Application number: 2025/90756	
What is the application for?:	Alterations to convert former public house to 6 flats
Address of the site or building:	Sir Robert Peel Inn, 14, High Street, Heckmondwike, WF16 0AR
Postcode:	WF17 5EP

User comments

**SITE LAYOUT & LOCATION PLAN
1.200 & 1.500**

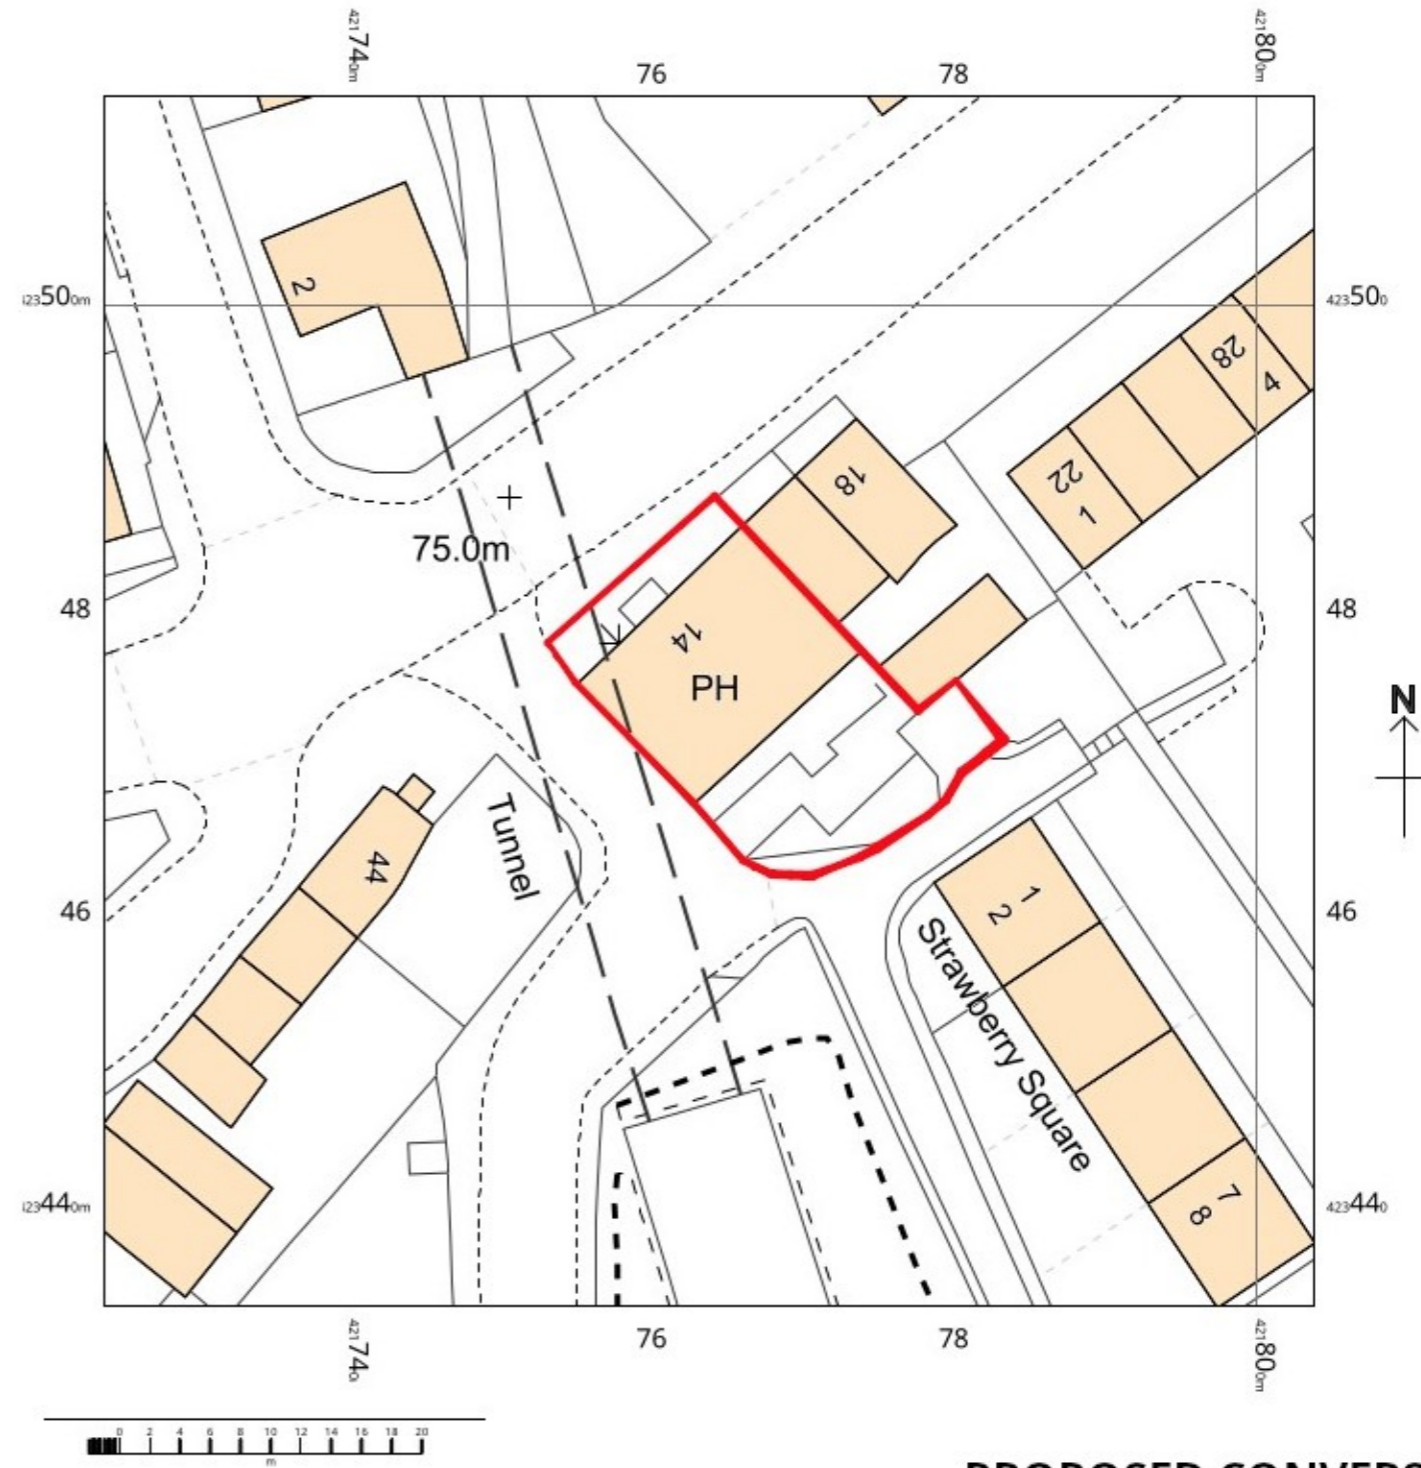
Type of comment: An objection	
Do you wish your comments to be published on the website anonymously?	<input checked="" type="checkbox"/> Yes
<p>The planning application has been filled in incorrectly in regard to biodiversity net gain. The application states that less than 25m² of habitat will be affected (claiming the de minimis exemption) and claims that the exterior is paved. However, this is not true the former garage and also the pub garden is vegetated, there is also vegetated areas on the verge on the public road. The total area of the former garage is 25m² alone, and the whole vegetated area is approximately 65m². The proposals include creating parking spaces within these areas (parking spaces 3-6 as shown on the site layout and location plans). Therefore, there will be a loss of habitat. The applicant therefore must consider biodiversity net gain.</p>
